Rezoning Transportation Analysis

Petition Number: 2023-032

Revision Log:

Date	Description
7-26-23	First Review (IW)
08-24-23	Second Review (NK)
11-29-23	Third Review (NK)

C:\Users\jrbanks\OneDrive\Dropbox\Banks Engineering\Dropbox\Banks Engineering\Projects\2023\081323\Kings College\DWG\RZ-02 SCHEMATIC SITE PLAN.dwg

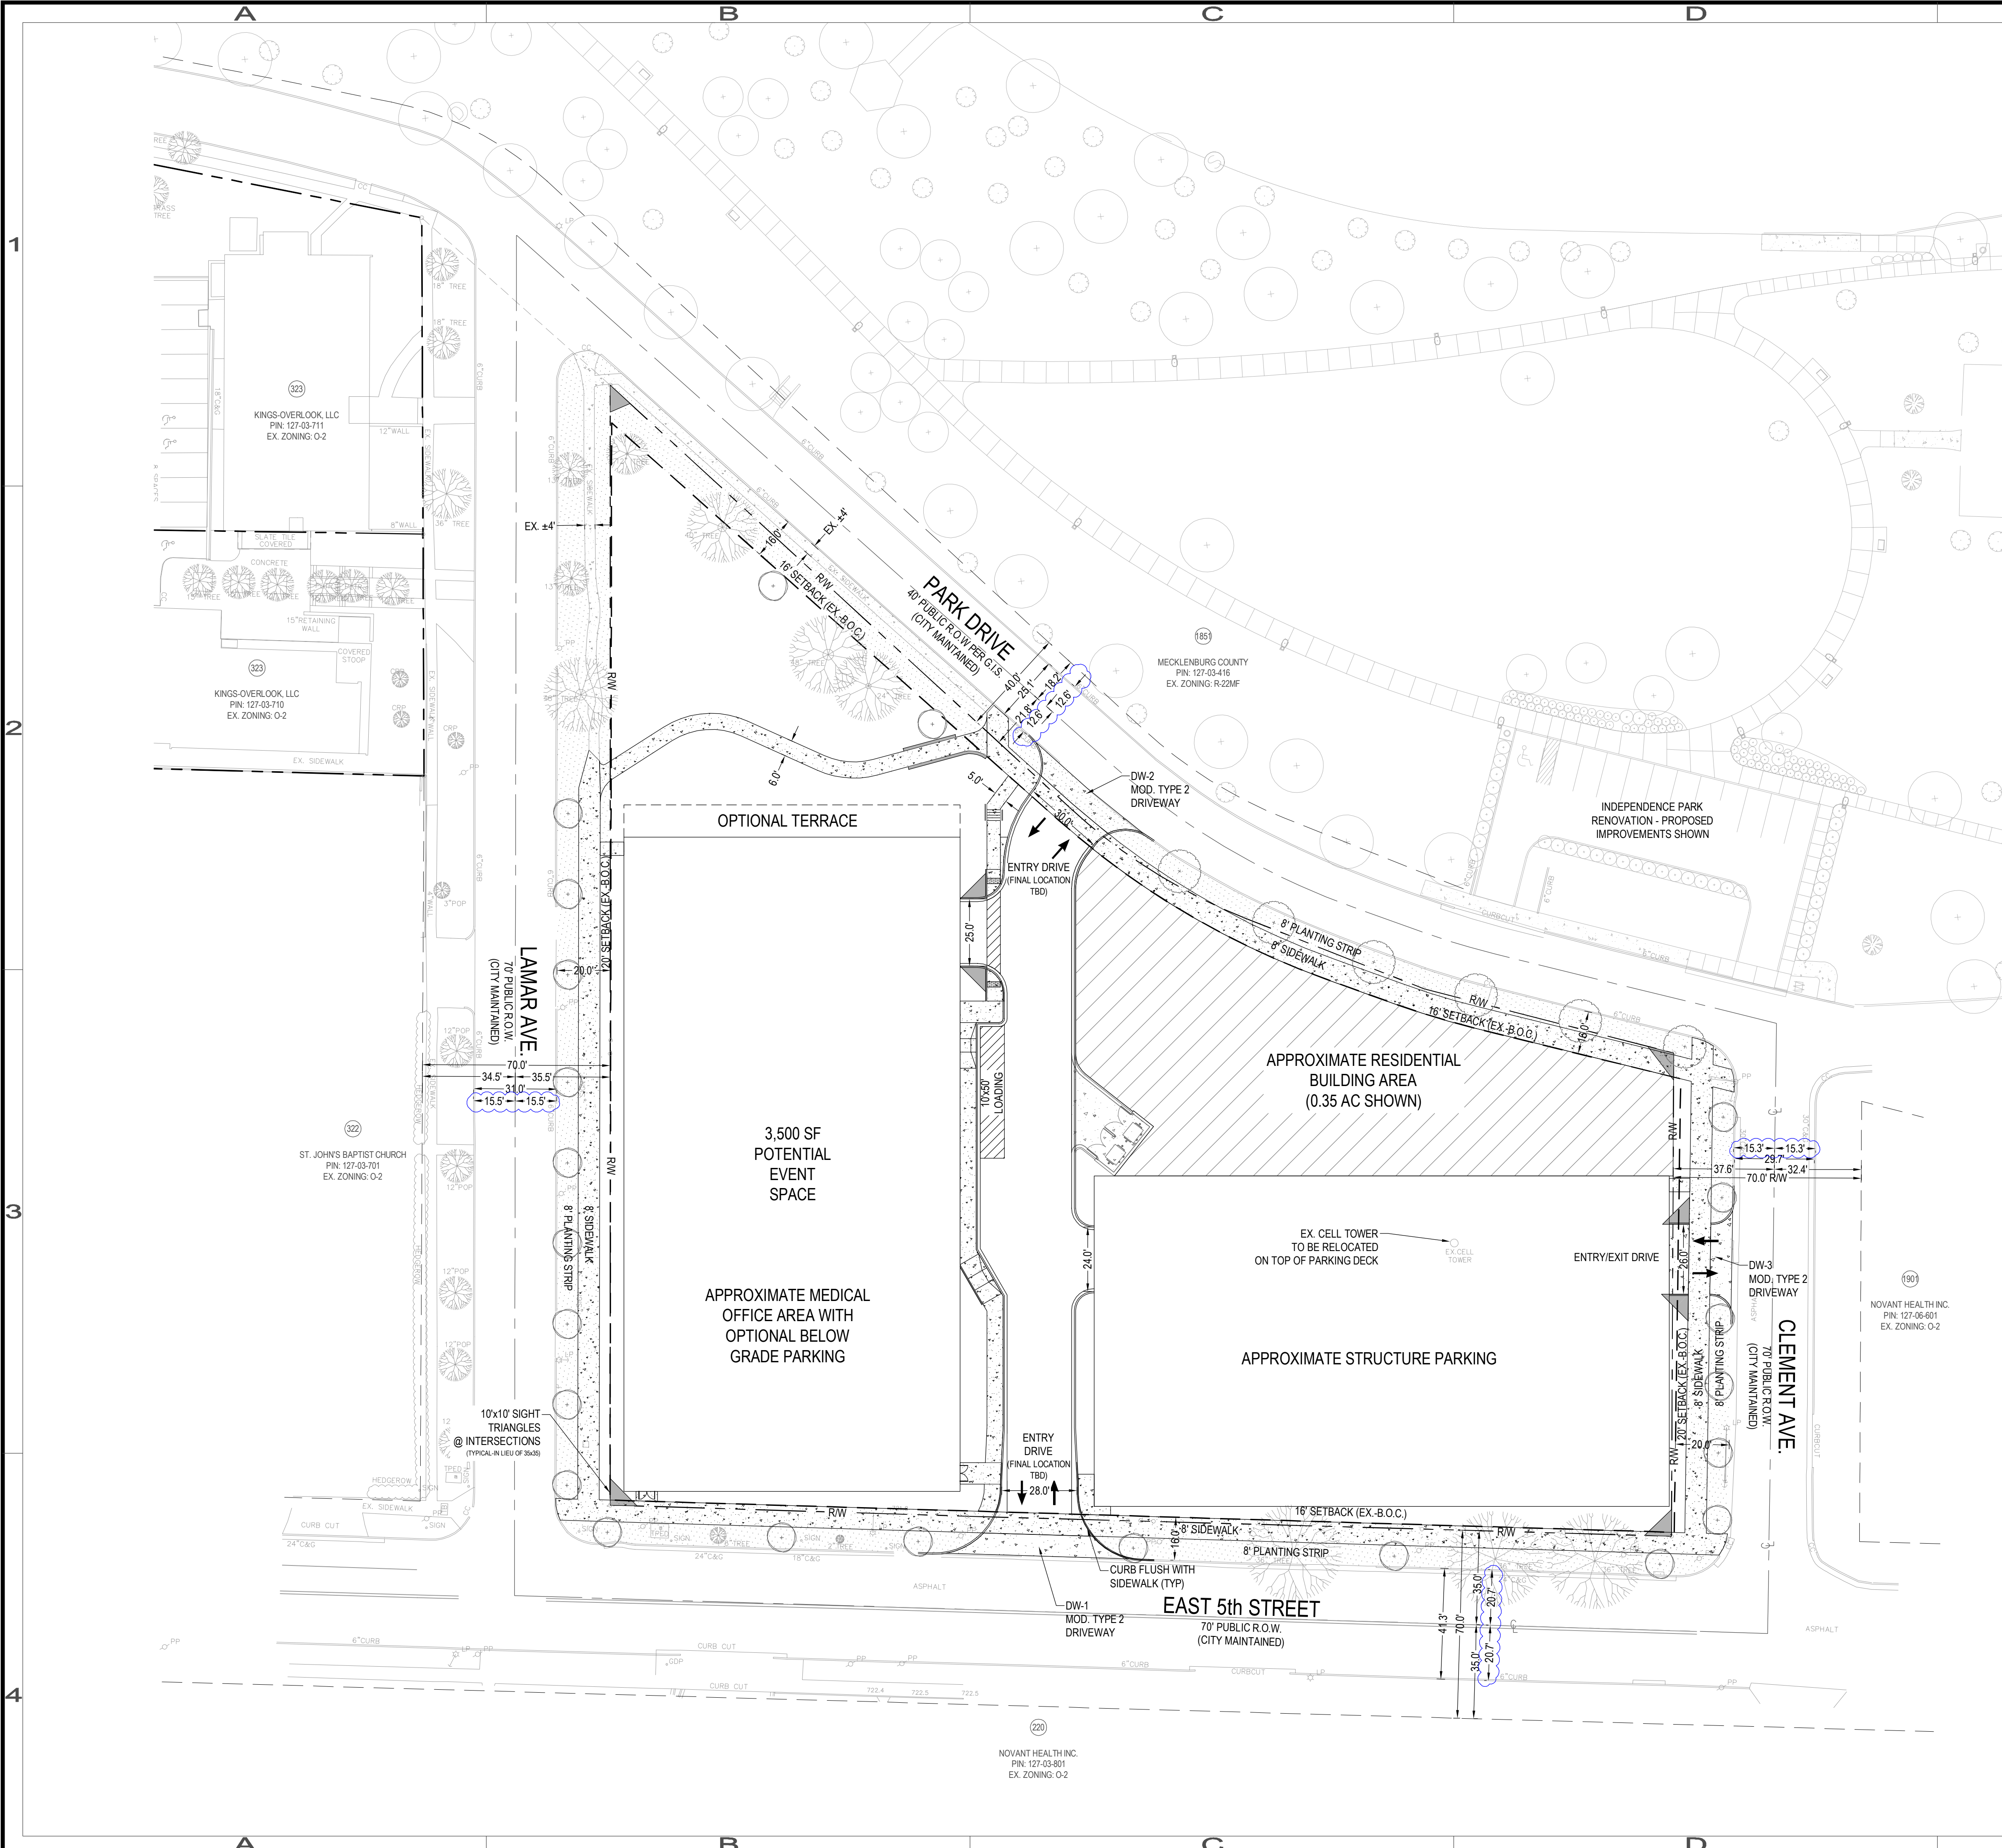
1. ~~Curbline:~~

- ~~a. The future location of curb and gutter is in the existing location for all abutting roads and matches previously approved rezoning.~~

~~NOTE: Additional distance from center line to back of curb may be required in locations where a median is present or around intersections and interchanges.~~

~~Label and dimension the curb and gutter from the centerline for each road on the site plan.~~
